SEARs for DFS Galleria Refurbishment The Rocks (SSD 6715)

Secretary's Environmental Assessment Requirements

Application Number	SSD 6751
Proposal Name	DFS Galleria Refurbishment
Location	Lot 2003 in DP 788428, 145 - 155 George Street, The Rocks
Applicant	DFS Australia Pty Ltd
Date of Issue	
General Requirements	The Environmental Impact Statement (EIS) must address the <i>Environmental Planning and Assessment Act 1979</i> and meet the minimum form and content requirements in clauses 6 and 7 of Schedule 2 the Environmental Planning and Assessment Regulation 2000. Notwithstanding the key issues specified below, the EIS must include an environmental risk assessment to identify the potential environmental impacts associated with the development. Where relevant, the assessment of the key issues below, and any other significant issues identified in the assessment, must include: • Adequate baseline data; • Consideration of potential cumulative impacts due to other development in the vicinity; and • Measures to avoid, minimise, and if necessary, offset the predicted impacts, including detailed contingency plans for managing any significant risks to the environment. The EIS must be accompan

PROJECT	DFS Galleria George St, Sydney				
CLIENT	DFS				
DRAWING	George St & Harrington St Demolition				
CLIENT REF & CONTACT	George St				
DATE	Nov 2014	DRAWN	RM	PROJECT#	2338
SCALE	NTS@A1	CHKD	ST	DWG#	DA106
				REVISION	c

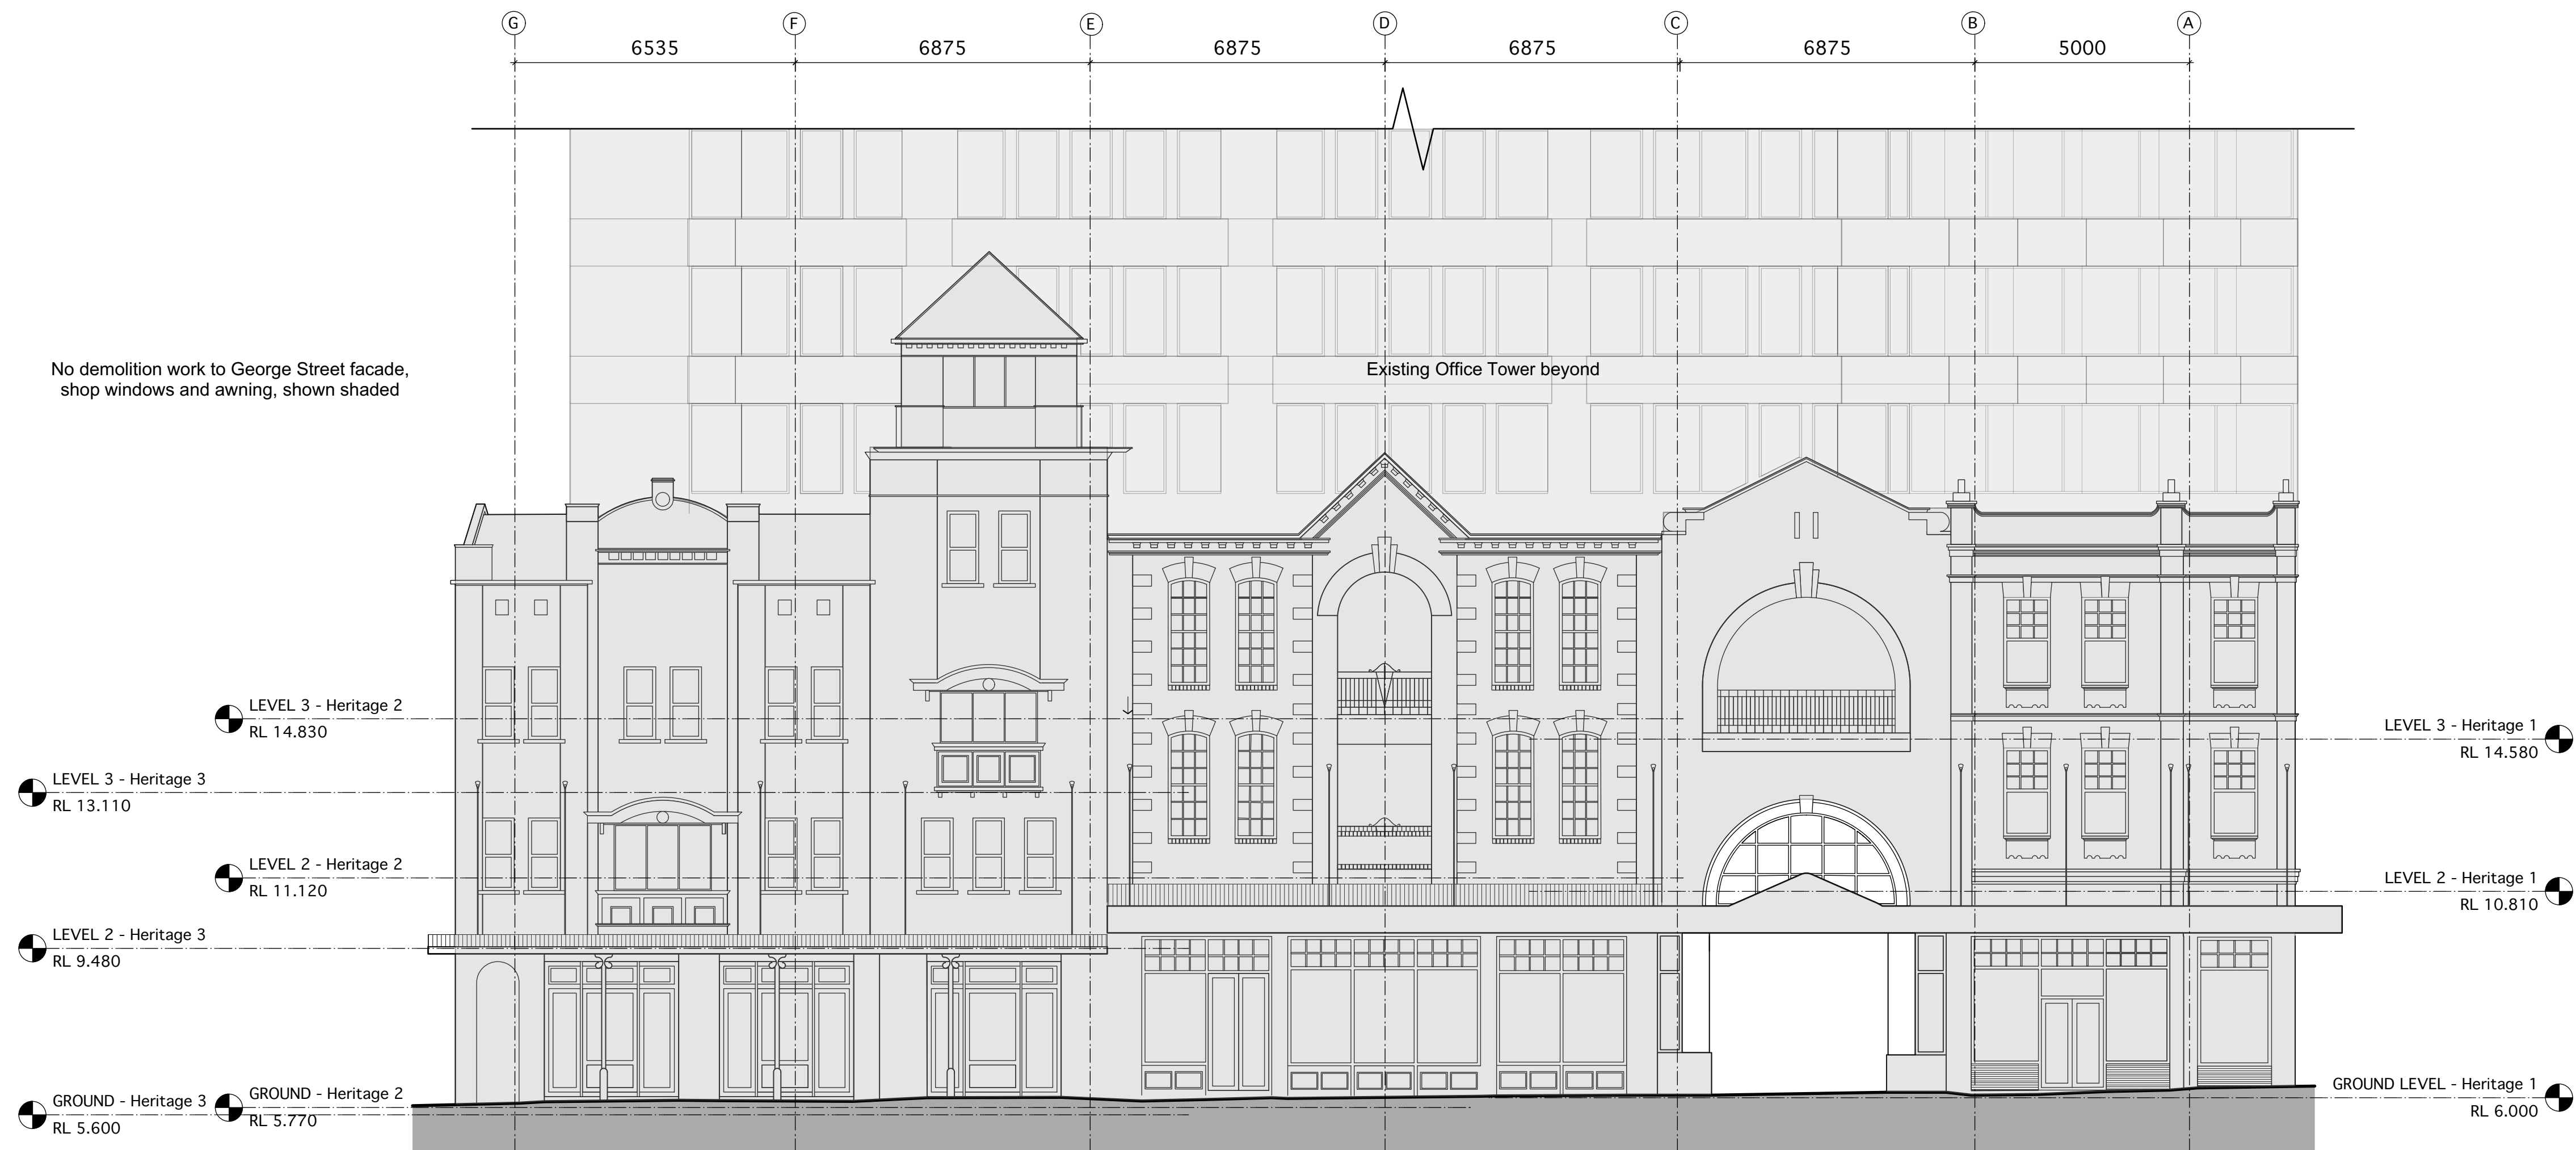
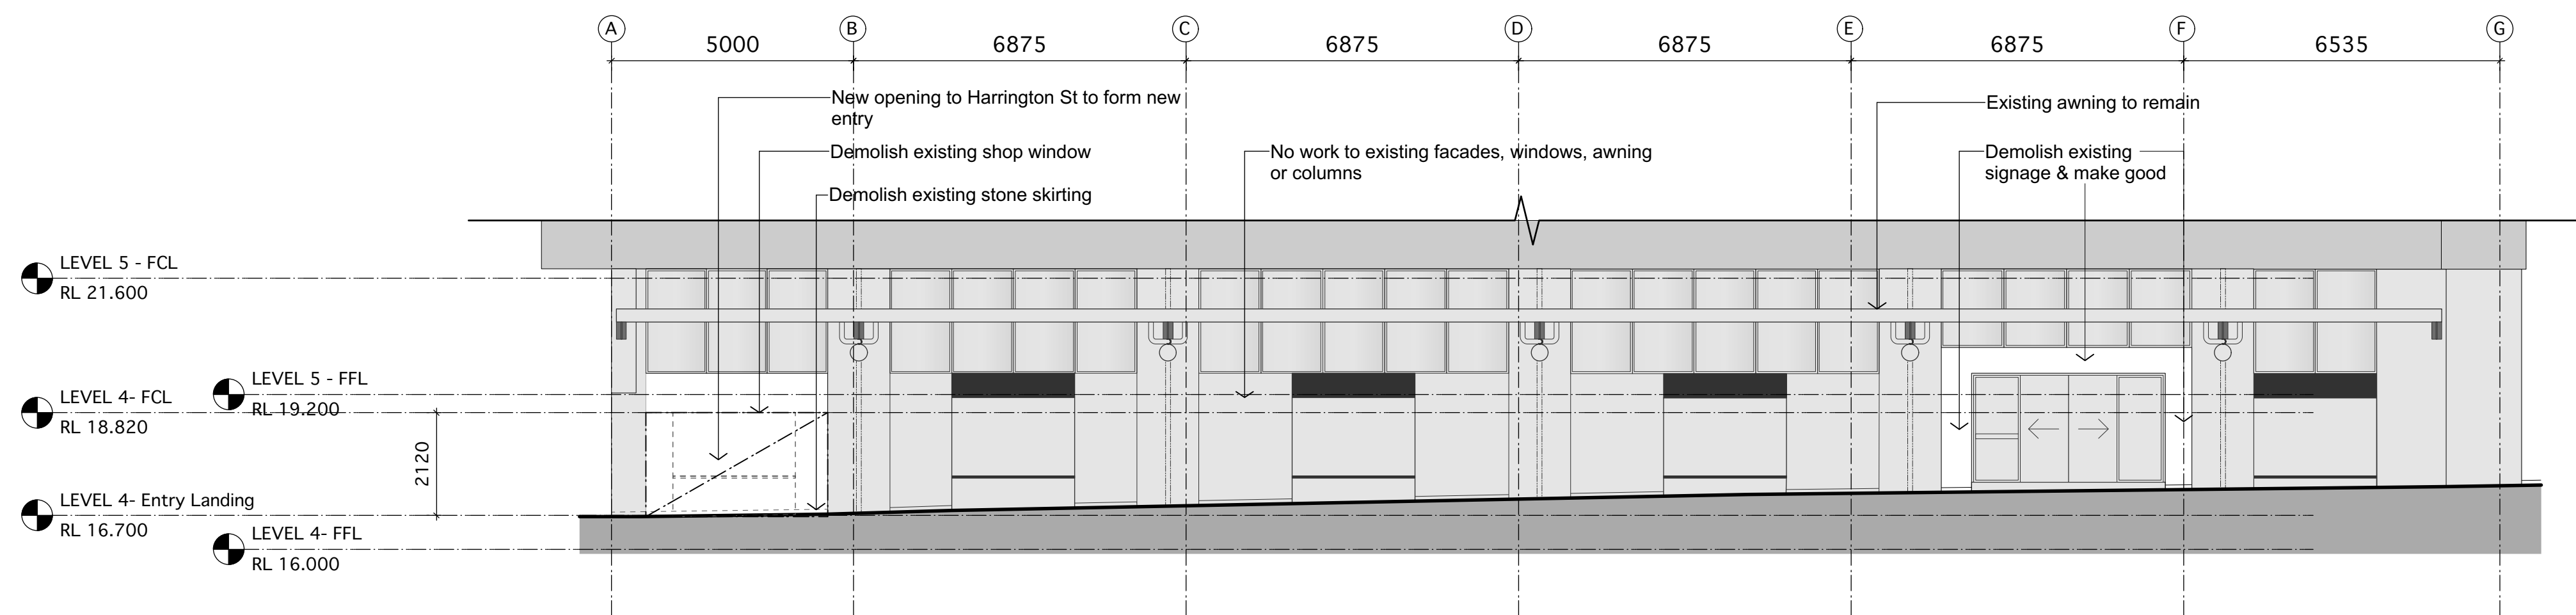
Notwithstanding the above, it is noted that the plans show the demolition of the existing Level 1 awning and replacement with a glazed awning on Level 2. Concern is raised regarding this element of the proposal. The location and material of the proposed awning is not considered to be appropriate in The Rocks area. The impact of the proposed awning on the significance of the building should be considered in detail as part of the application.

- The predominant awning form within The Rocks is the traditional style with a fascia. The Authority considers the proposed installation of a glazed awning is unacceptable and would create an undesirable precedent for the streetscape of George Street, as it would not provide consistency or complement the architectural style of the host buildings or respond to the streetscape. The Department should request that this aspect of the proposal be excluded from any future application.

- Whilst the significance of existing awning is rated as 'moderate' in the CMP for the site, it is a 1992 reconstruction of the earlier awning, including the verandah-style awning with turned timber posts and decorative metal brackets to 153-155 George Street. The awning forms an important part of the composition, and supports the significance of the item.

- The Authority notes that the City of Sydney's awning policy recommends that proposed new awnings be compatible with existing awnings, and recommends that *"A traditional awning form is generally appropriate in the following situations: adjacent to heritage items that have a traditional awning; where the existing streetscape is predominantly composed of traditional awning forms; where adjacent buildings have a traditional awning form. Steeply sloped, arched or barrel vaulted awnings are not permitted"*. (City of Sydney awnings policy 2000; item 2.2 Form and Context).

- The Authority's preference is not to reinforce the prominence of the arched entrance over No. 147 George Street; the CMP recommends that *"when the opportunity arises, reconstruct the George Street elevation of 147 George Street to better interpret its original streetscape qualities"* (CMP page 13; item 1.5 Vision). This would involve the reinstatement of the earlier configuration of the former recessed porch to the first floor. It should be noted that the former barrel vaulted awning which was installed c. 1988-1990 was removed c. 1998 and replaced with the more current awning which is more sympathetic to the original façade treatment of the building.

- Whilst the current shopfronts date from the 1980s their "reinstatement" has been based on early photographs of 153-155 George Street (CMP page 119). These facades "contribute" aesthetically to the overall richness and are "sympathetic in scale and character" to the significant setting of George Street (CMP page 48). The scale, character and detail of the painted timber shopfronts should be retained.

PROJECT					
DFS Galleria George St, Sydney					
CLIENT					
DFS					
DRAWING					
Globe St Demolition					
CLIENT REF & CONTACT					
George St					
DATE	Nov 2014	DRAWN	RM	PROJECT#	DWG#
SCALE	NTS@A1	CHKD	ST	2338	DA107
					C

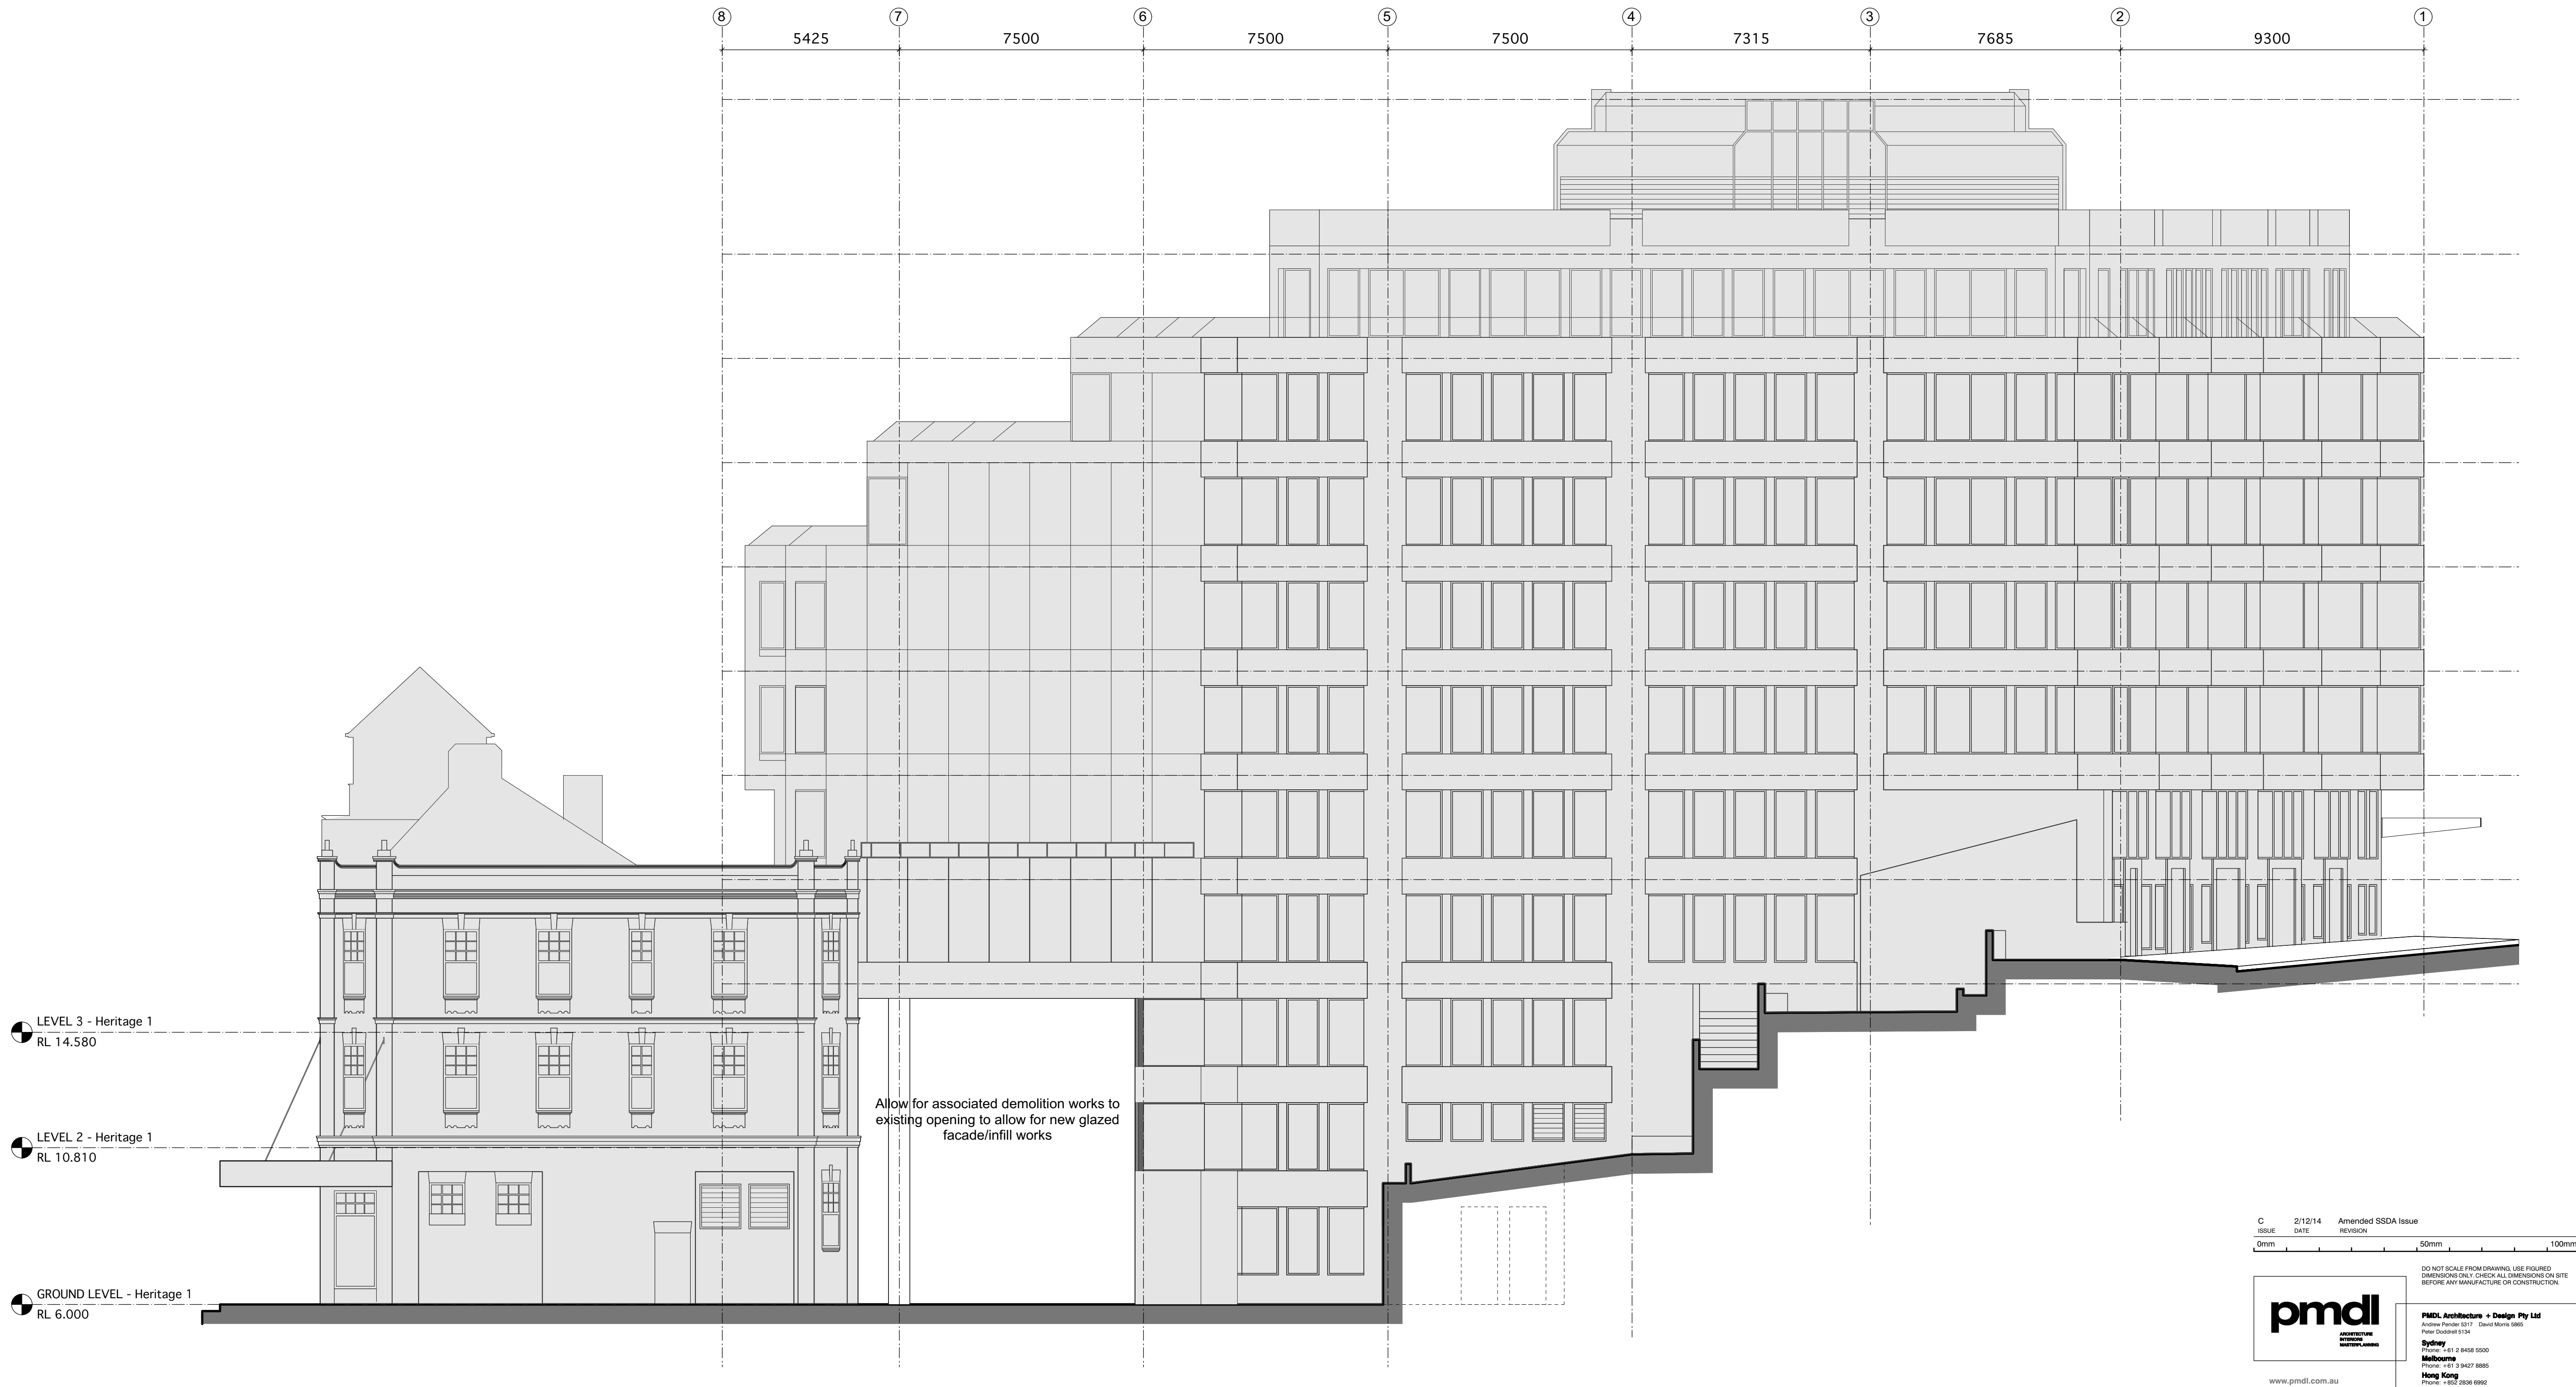
- The plans provided for comment with the draft SEARs indicate that this part of the building will be fitted with fixed glazing with a doorway at the eastern end. The Authority's priority is to retain and enhance pedestrian access off Globe Street and the nearby stairs.
- The Conservation Management Plan (CMP) that applies to the subject site recommends that future works "*investigate opportunities for the removal of intrusive elements, such as the grille and fire doors on the Globe Street elevation*" (CMP 2012 page 13; item 1.5 Vision).
- The SEARs should recommend that opportunities be explored to improve pedestrian access off Globe Street and the removal of intrusive elements from the Globe Street elevation.
